Application by North Somerset Council for an Order granting Development Consent for the Portishead Branch Line – MetroWest Phase 1

Hearing Action Points arising from the Issue Specific Hearing 2 dealing with Environmental Matters (day 1 of 2) held virtually on Monday 11 January 2021

Drawing
**PORTISHEAD STATION CAR PARK
LAYOUT, LANDSCAPING AND NEW
BOULEVARD AND ACCESS PLAN
SHEET 1 OF 3**

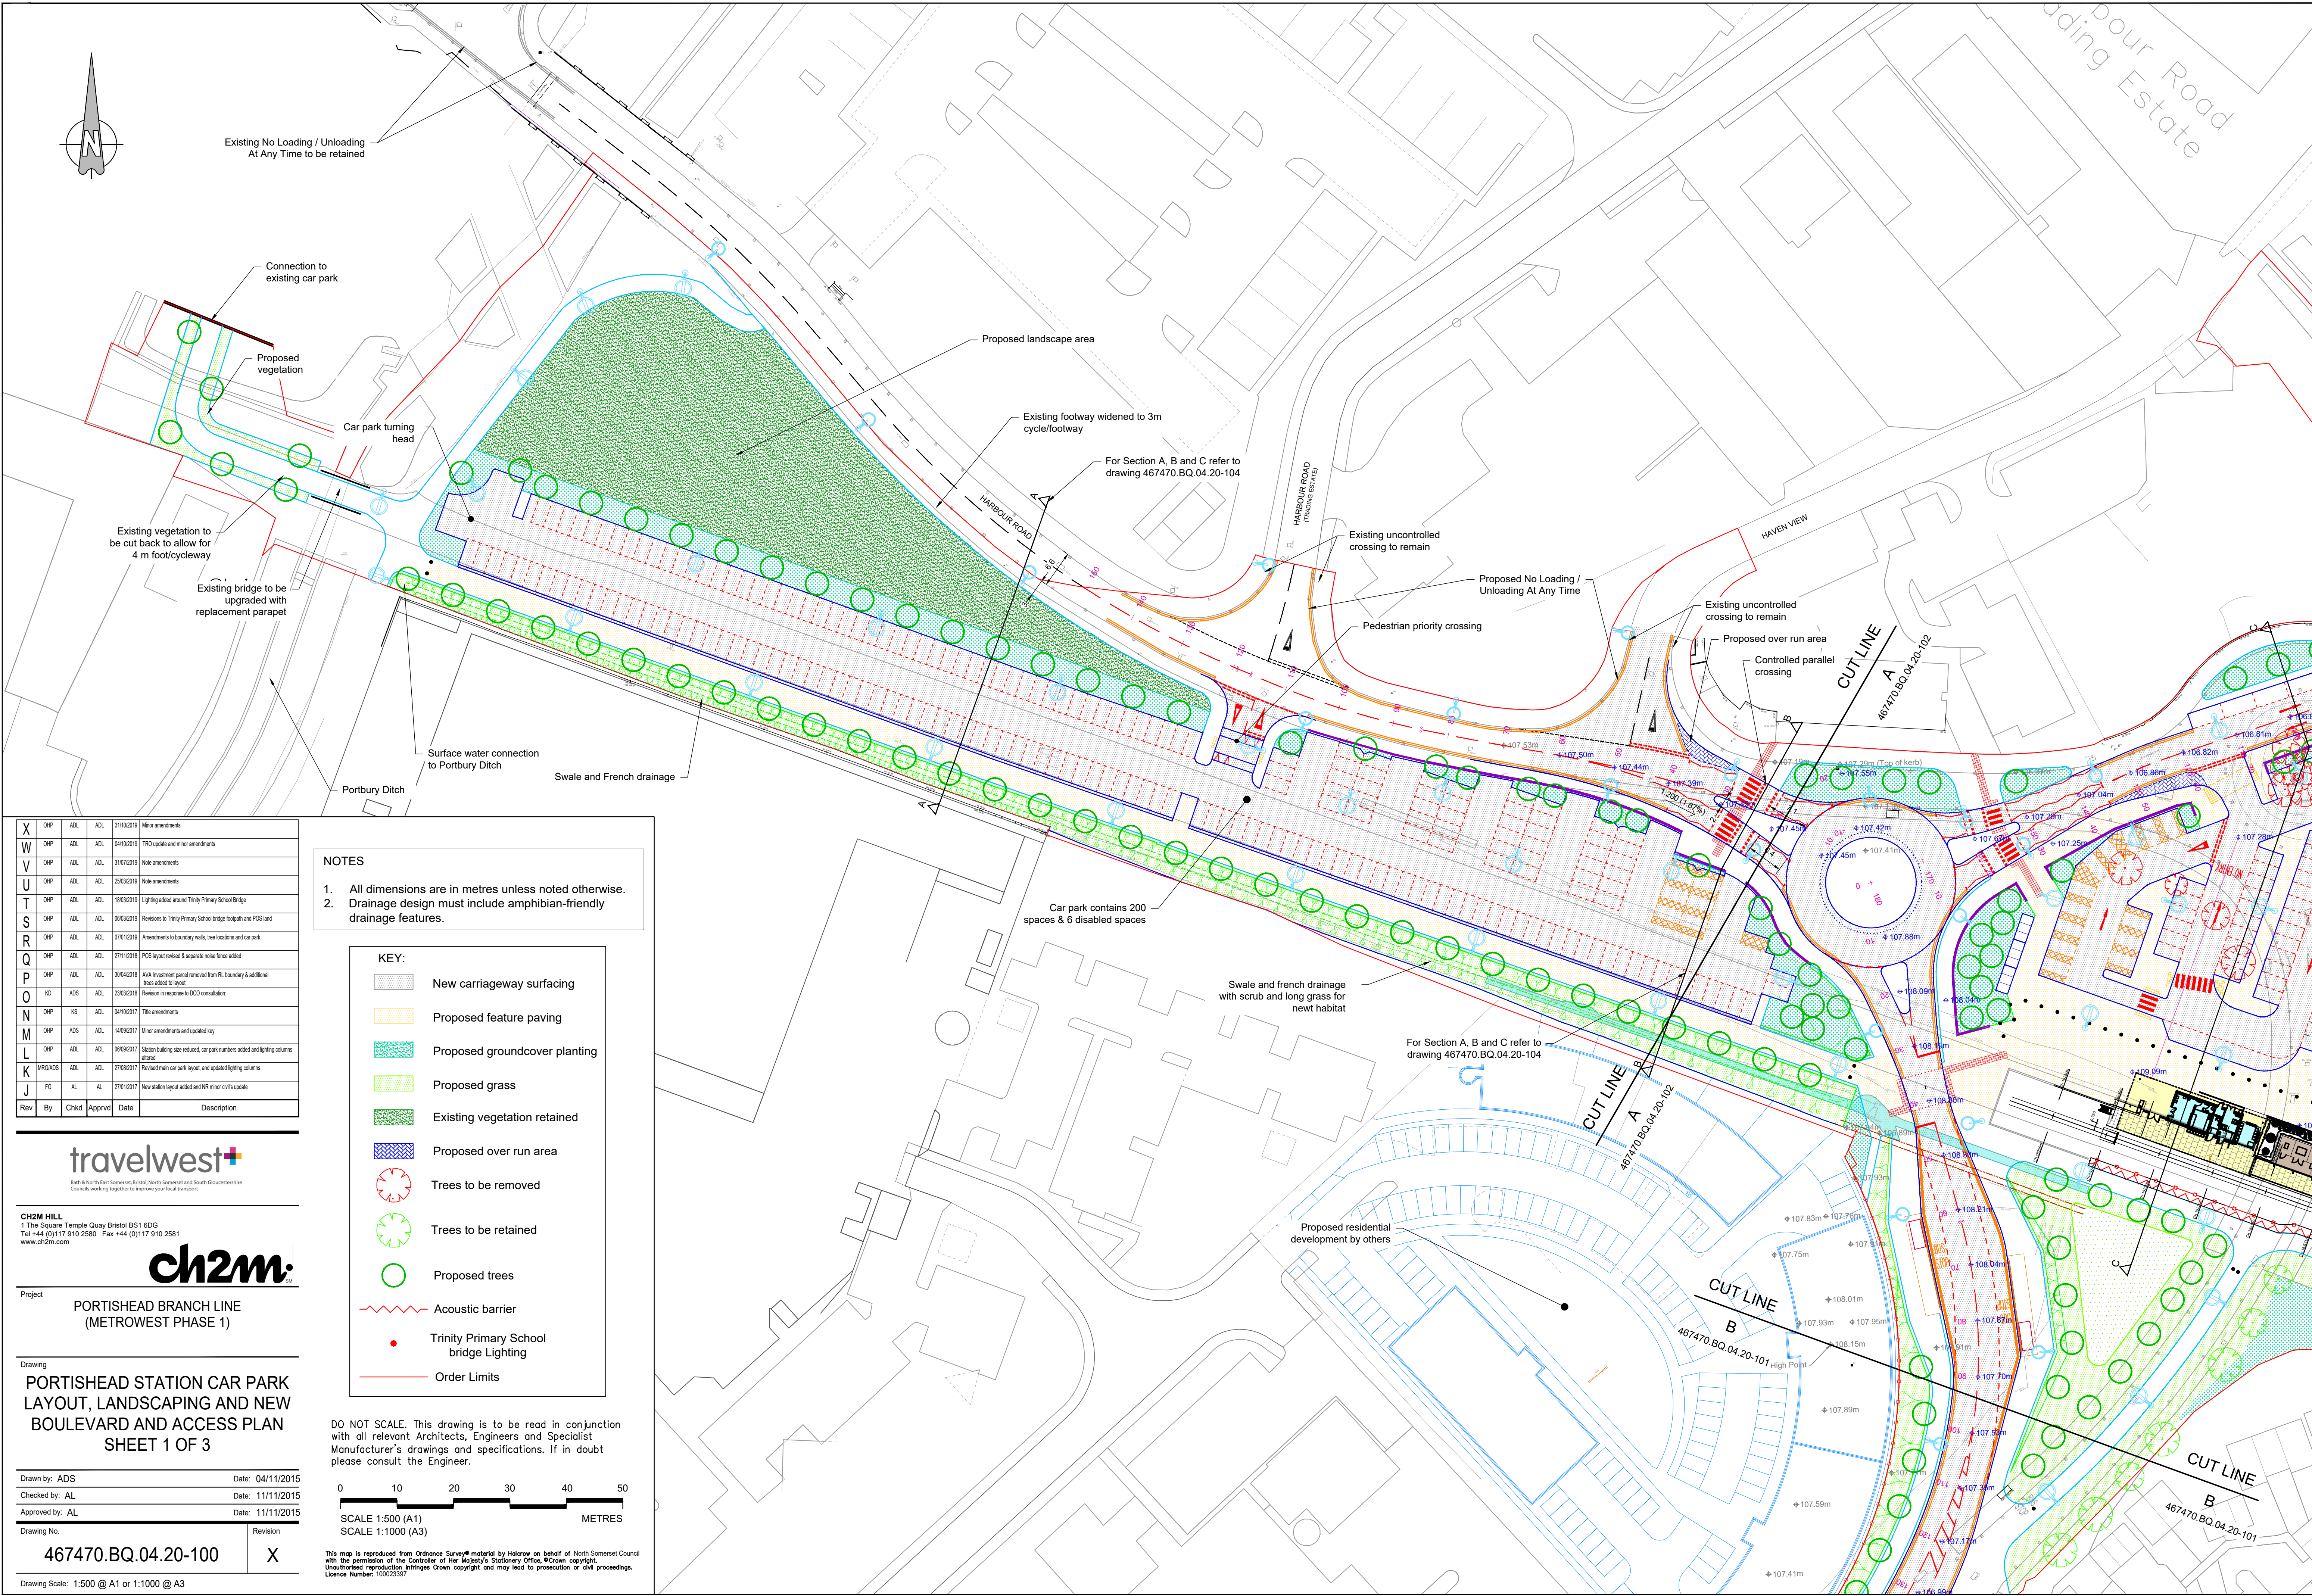
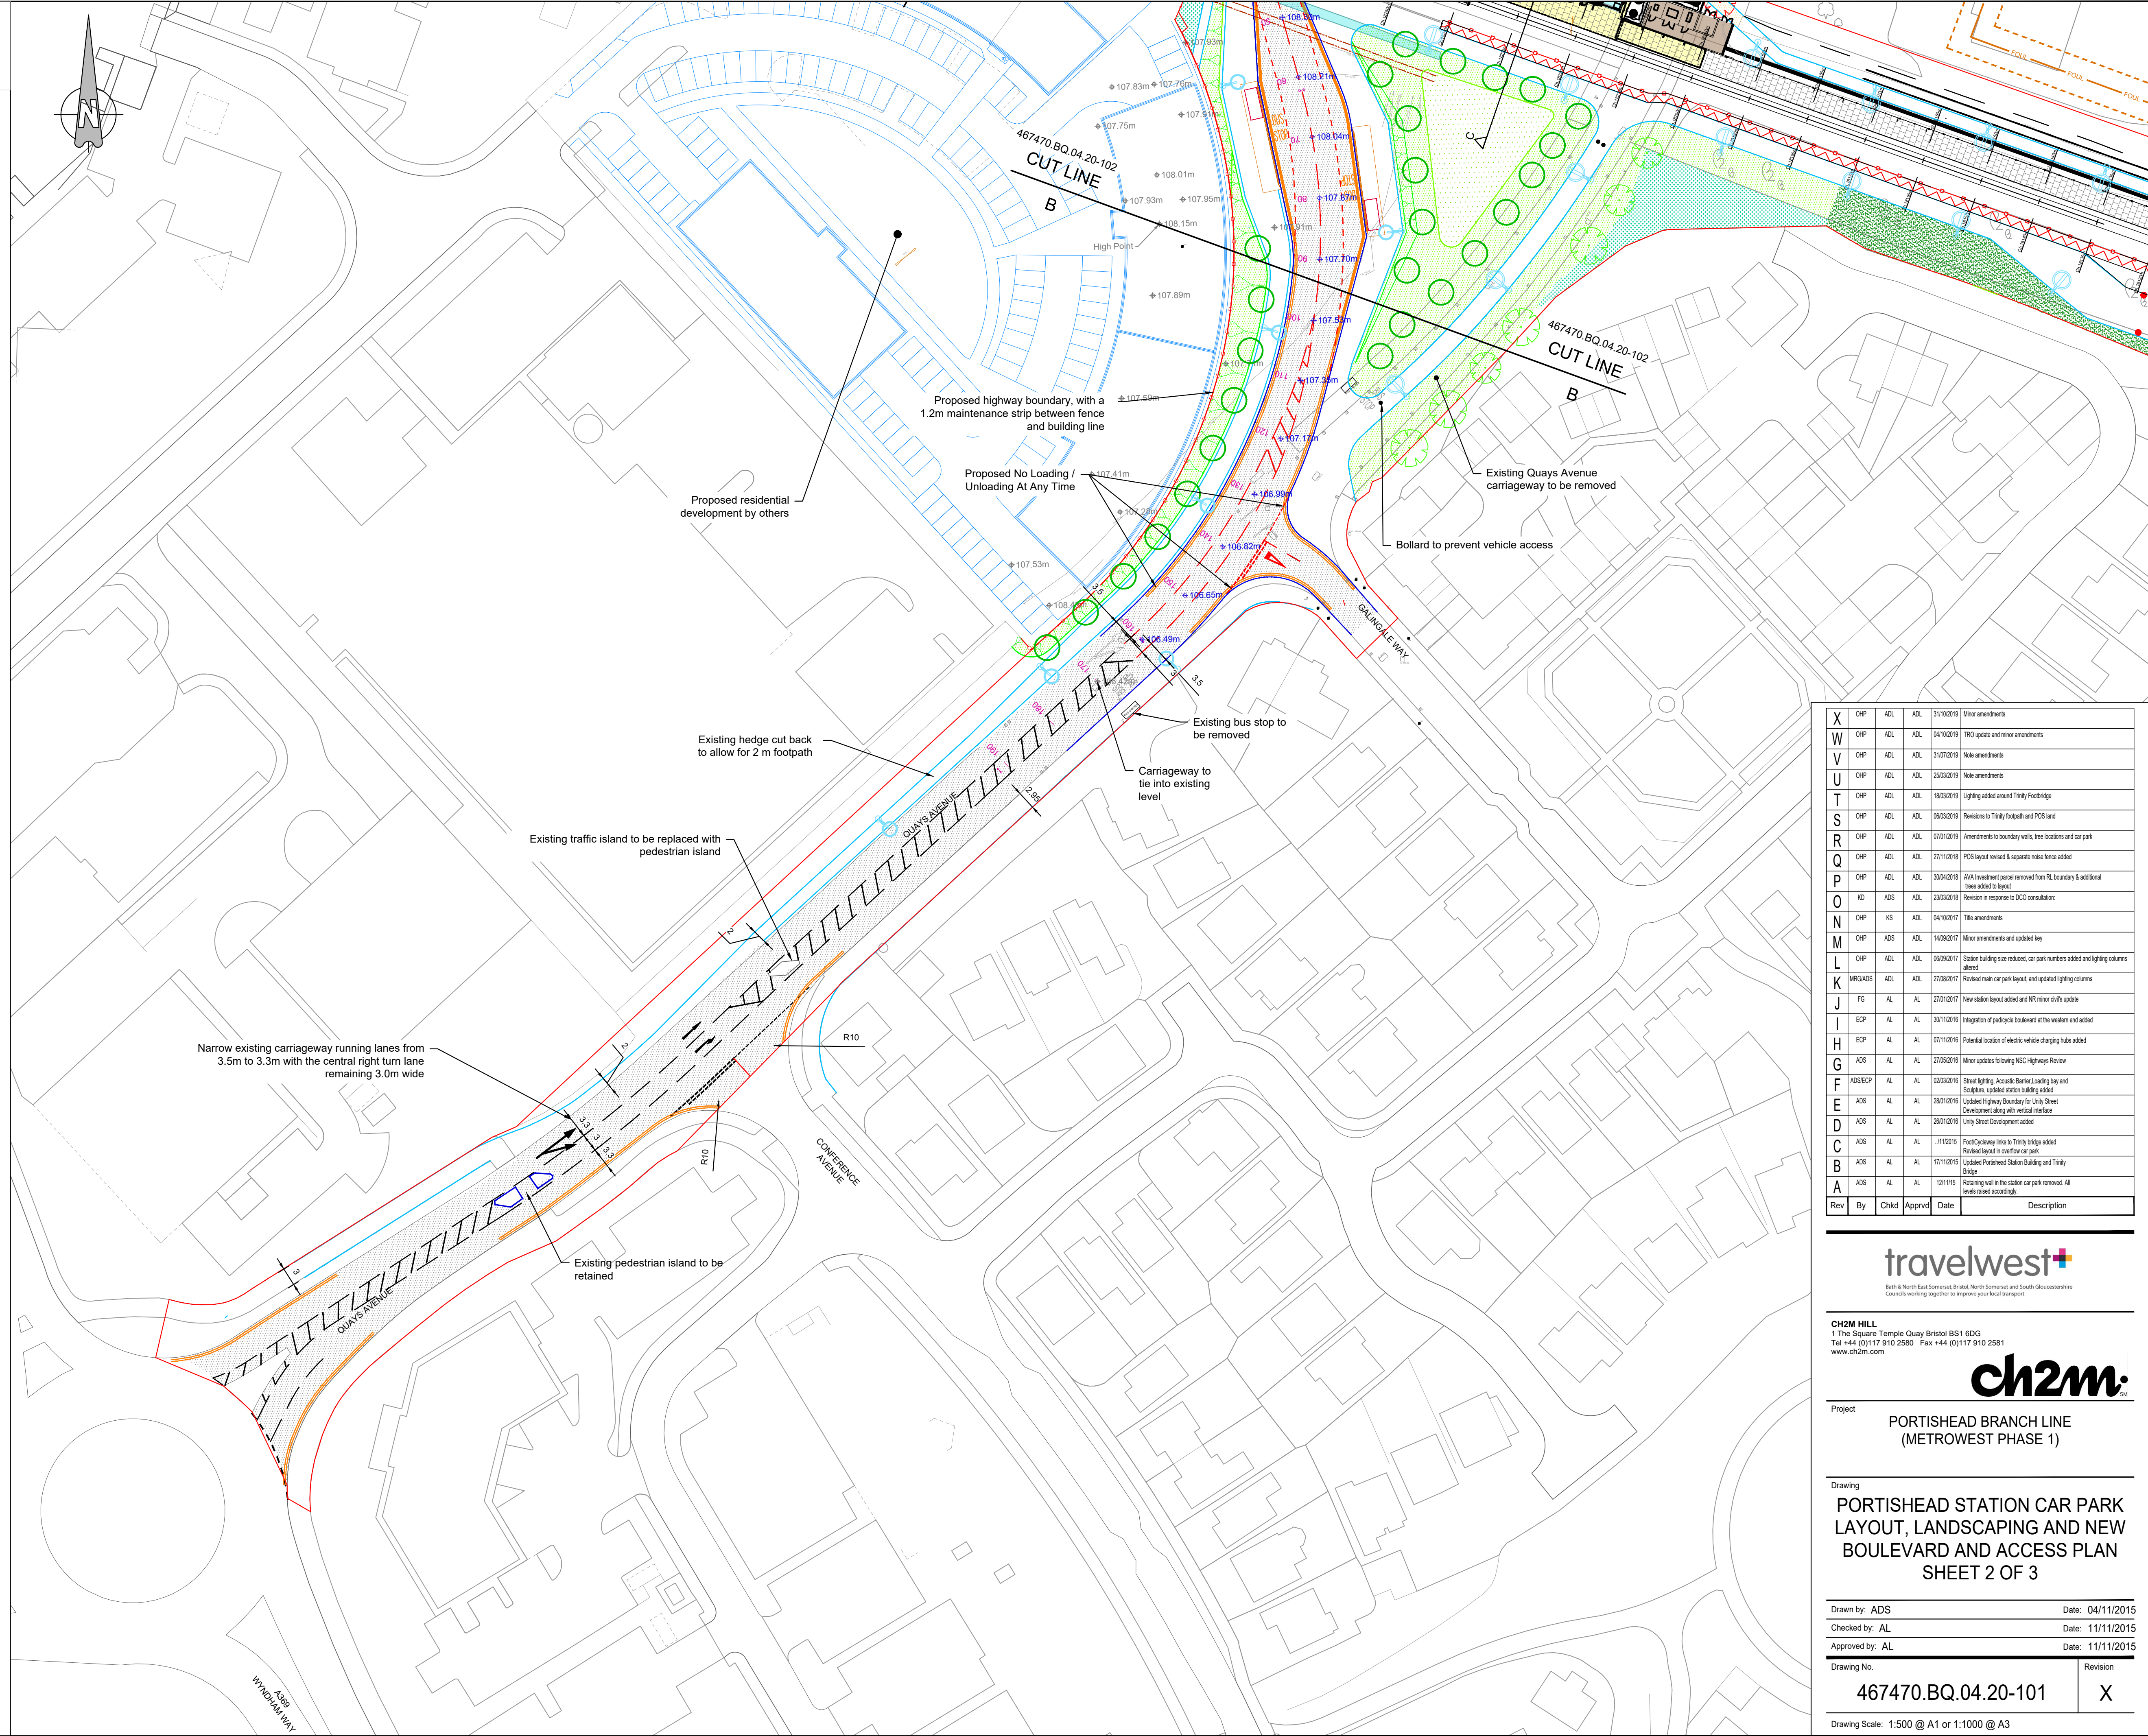
Action	Description	Action by	When
1	Consider what energy-efficiency/ micro-generation measures that could be incorporated into the design of Portishead Station and explain how these would be secured	Applicant	Deadline 4
2	Review the visual impact assessment to see whether the effect of Portishead Station and forecourt on the care home has been assessed in terms of setting of and outlook from the care home and signpost where in the application documentation this assessment is. If it has not been assessed either provide an assessment or an explanation as to why such an assessment would not be necessary. Confirm the correct name of care home	Applicant	Deadline 4
3	Invite the Town Council as they were not in attendance at the hearing the opportunity to provide any further comments on the design of Portishead Station and footbridge following the comments made at the hearing	Portishead Town Council	Deadline 4
